Norfolk County Council

Local Impact Report

Sheringham Shoal & Dudgeon Extension Projects – submitted Development Consent Order application

January 2023

- C282-MU-Z-XD-00118-01\_F02 – Substation Outline Drainage Plan – Infiltration Method
- C282-MU-Z-XD-00122-01\_F02 – Substation Drainage – Sewer Connection Plan and Long Section

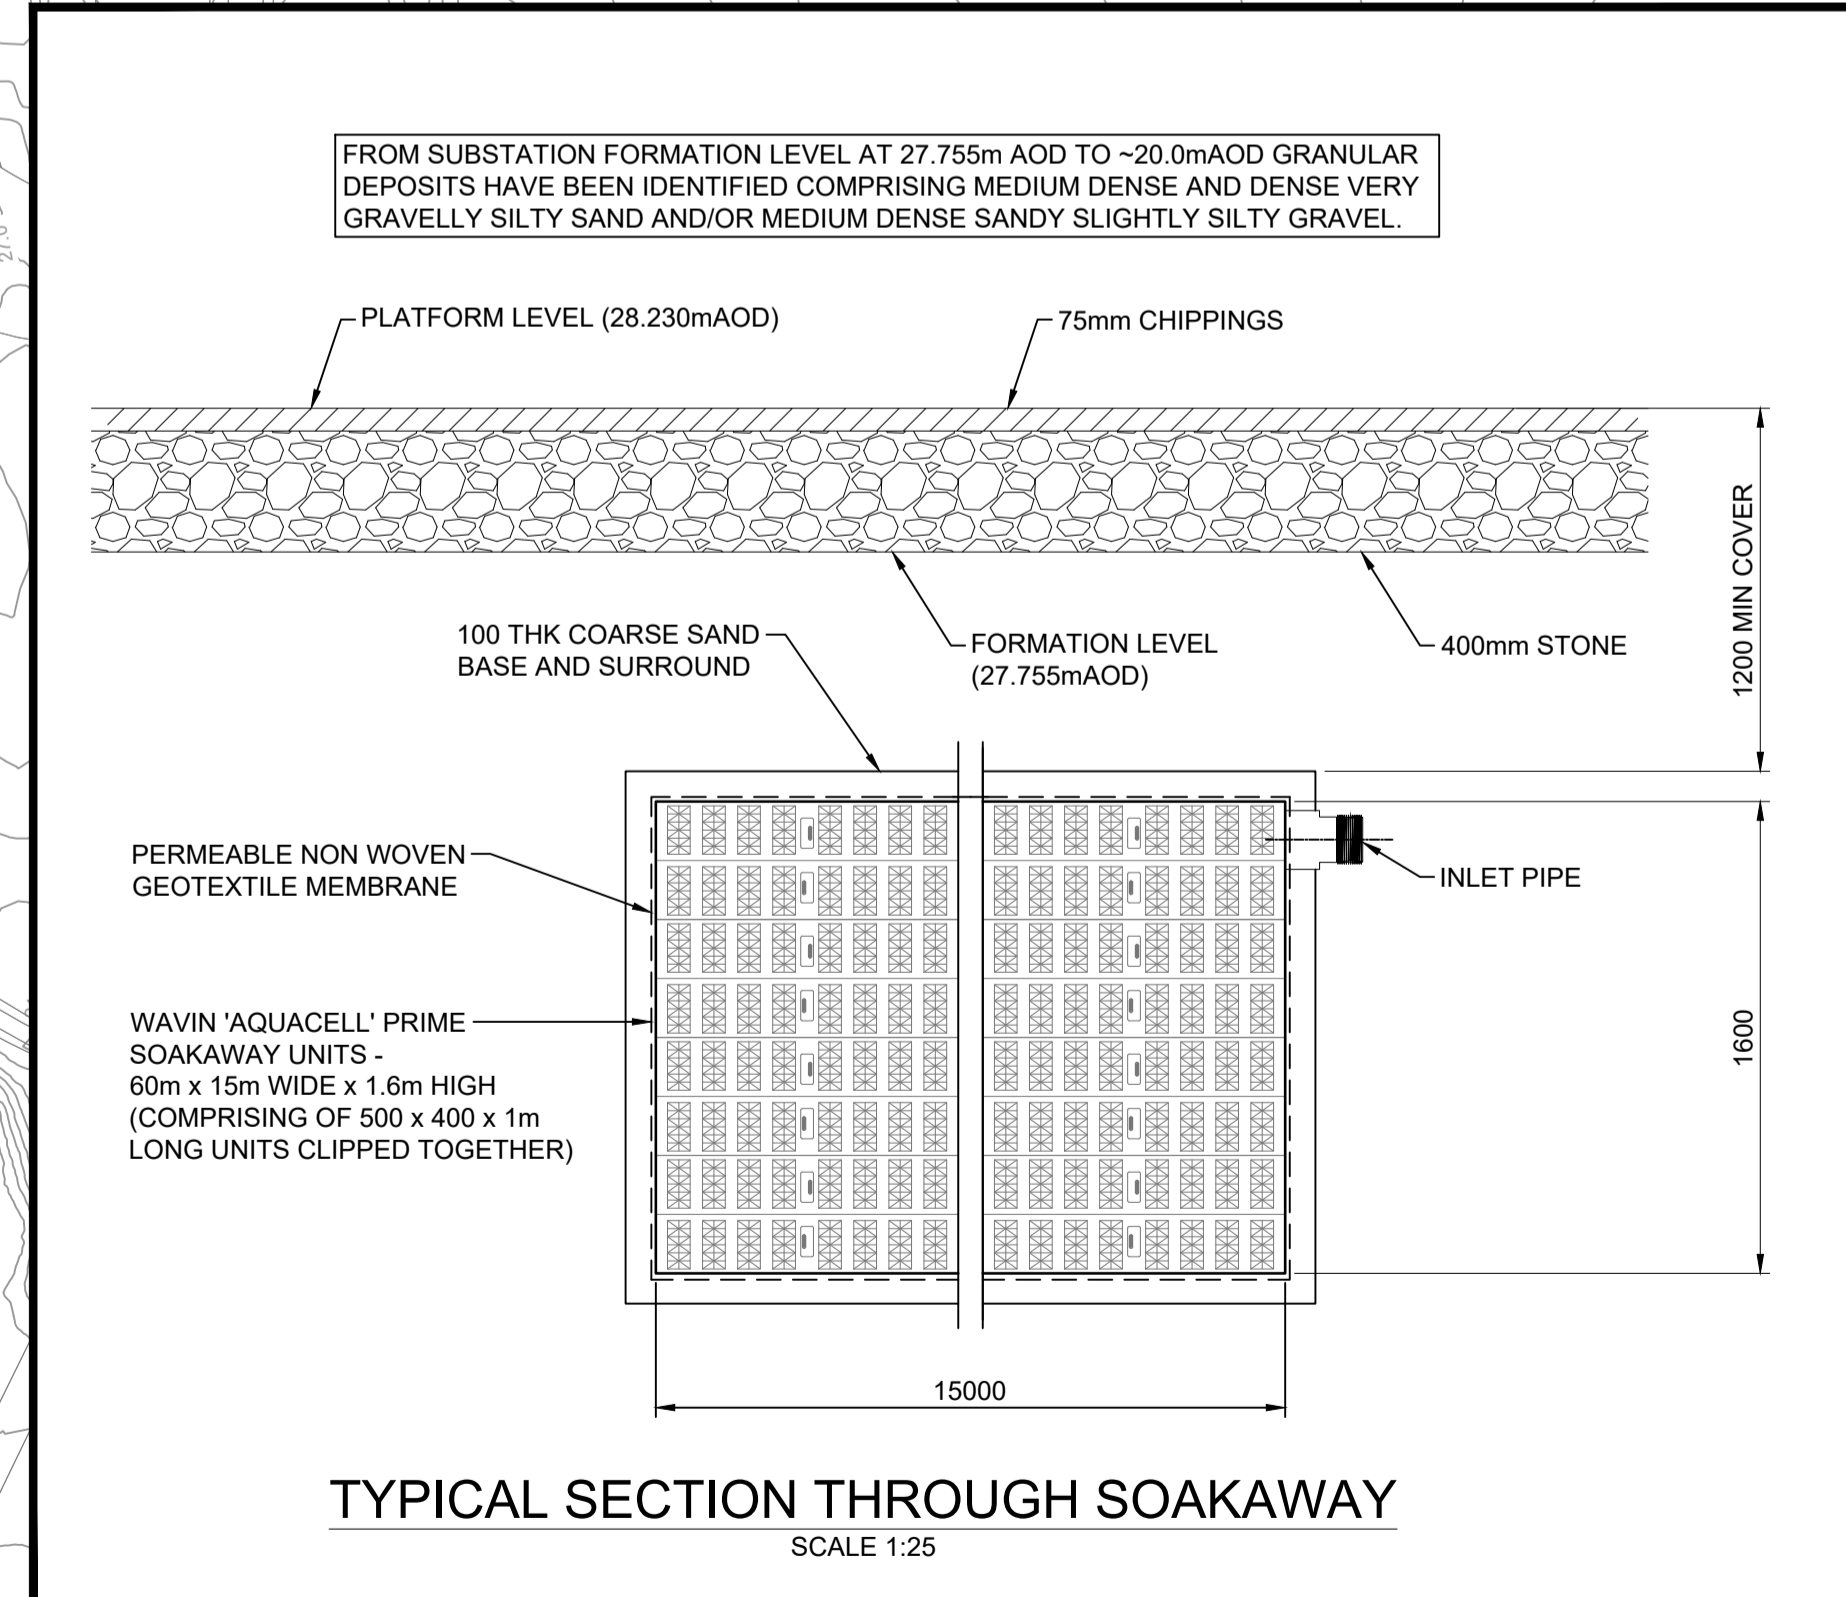
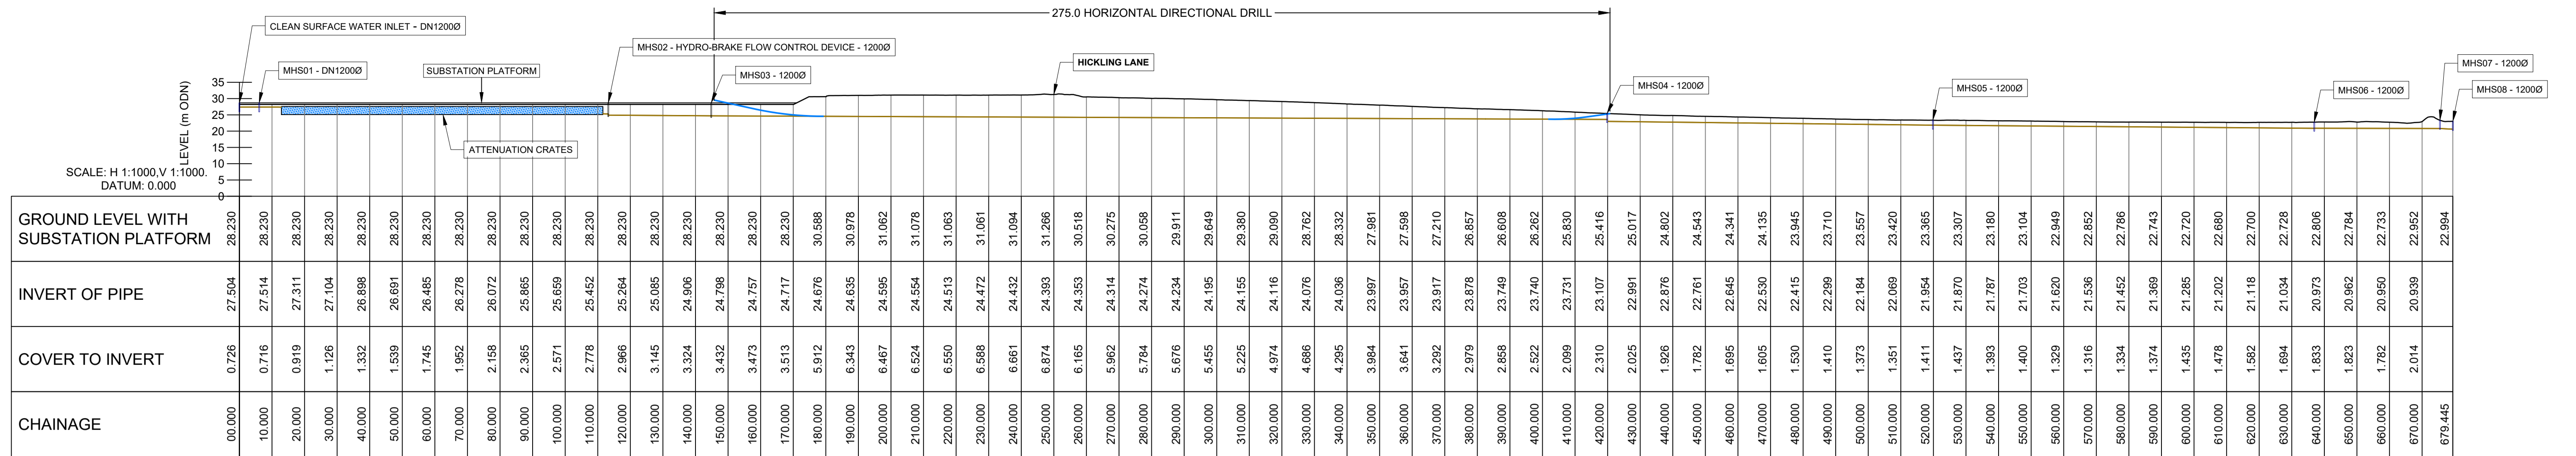
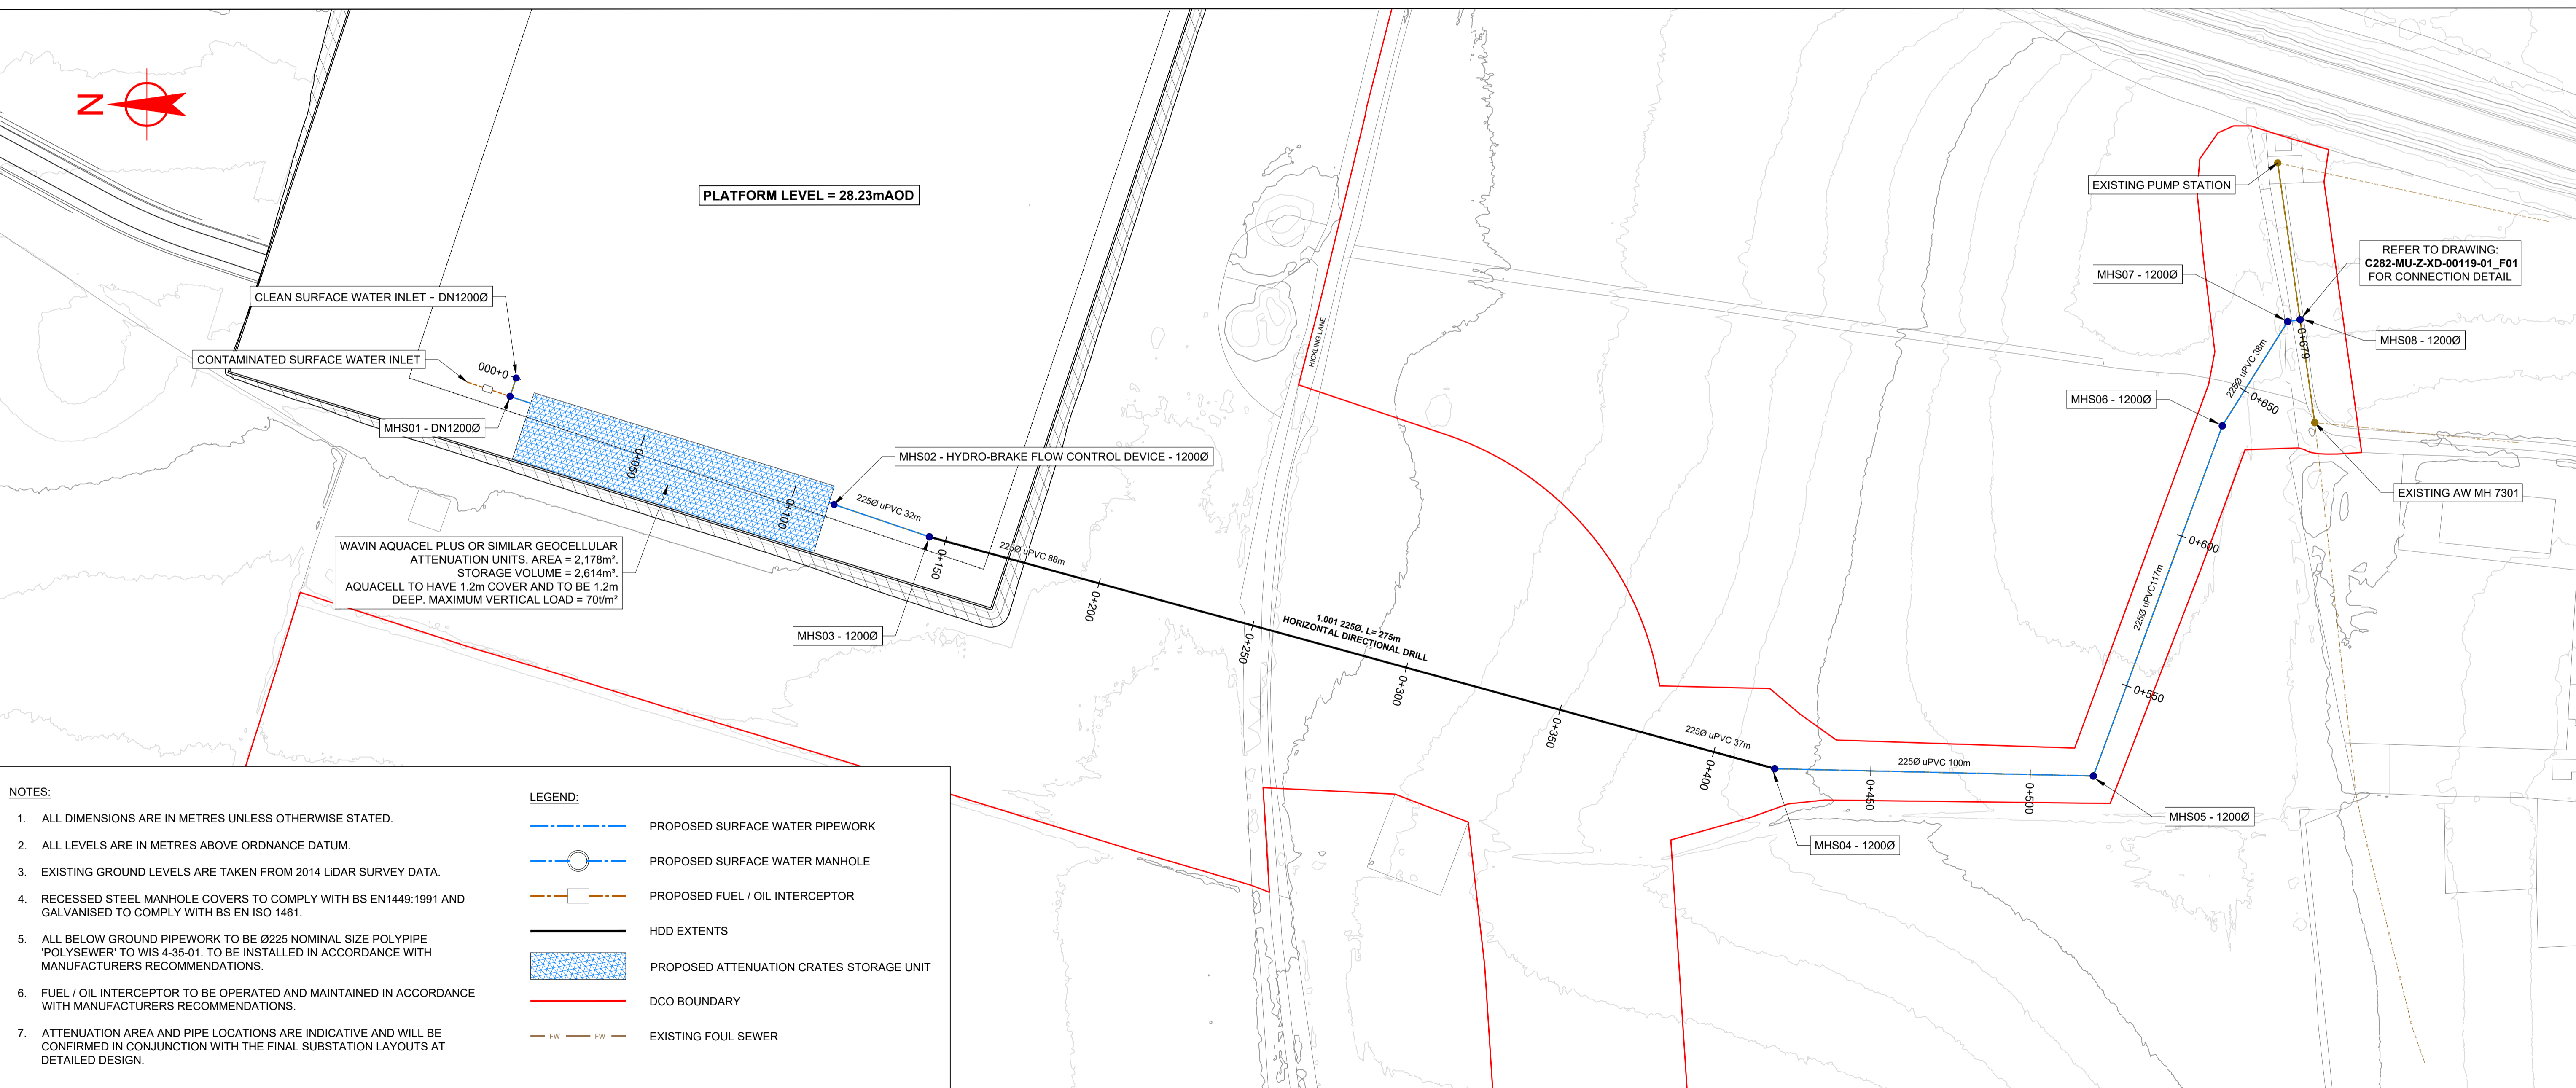
- 4.7.1. At present, two outline surface water drainage designs have been developed but neither has been selected as the preferred option as the applicant is not yet able to state where they are intending to discharge surface water to for disposal. Further information on the proposed surface water drainage will need to be provided for the Lead Local Flood Authority (LLFA) to review.
- 4.7.2. At this stage, the County Council as the LLFA has considered the outline surface water drainage design as set out in the Outline Operational Drainage Plan; as well as the Flood Risk Assessment (FRA); Onshore Sub-station Drainage Study; and accompanying Hydraulic Modelling. At this time, further evidence and clarification of information is required to demonstrate:

1. An updated FRA and Drainage Strategy that confirms the proposed surface water discharge location for the onshore sub-station.
2. The provision of a sustainable surface water drainage design details for the proposed for the Onshore Sub-Station with support calculations and plans.
3. The provision of the site-specific greenfield runoff rates and volumes, the comparable post-development runoff rate and volumes.
4. An updated hydraulic model that appropriately applies the latest climate change allowances and provides an assessment of the change in flood risk.
5. Adequate consideration of the surface water flood risk associated with discharging to the foul sewer in Swainsthorpe and the residual risks.
6. A maintenance and management plan detailing the activities required and details of who will adopt and maintain all the surface water drainage features for the lifetime of the development.

4.7.8. The FRA based on the Drainage Study identified the two most feasible surface water drainage options were either discharge to the Anglian Water Sewer in Swainsthorpe or to discharge to infiltration. However, no conclusion as to which option was preferred was reached in either the FRA or the Drainage Strategy. The LLFA acknowledges that while neither of these solutions are preferable, the options available at this location are very limited and constrained.

- 4.7.18. The Drainage Study identified the two most feasible options were either discharge to the Anglian Water Sewer in Swainsthorpe or deep bore infiltration. However, no conclusion of which options was preferred was reached in the study.
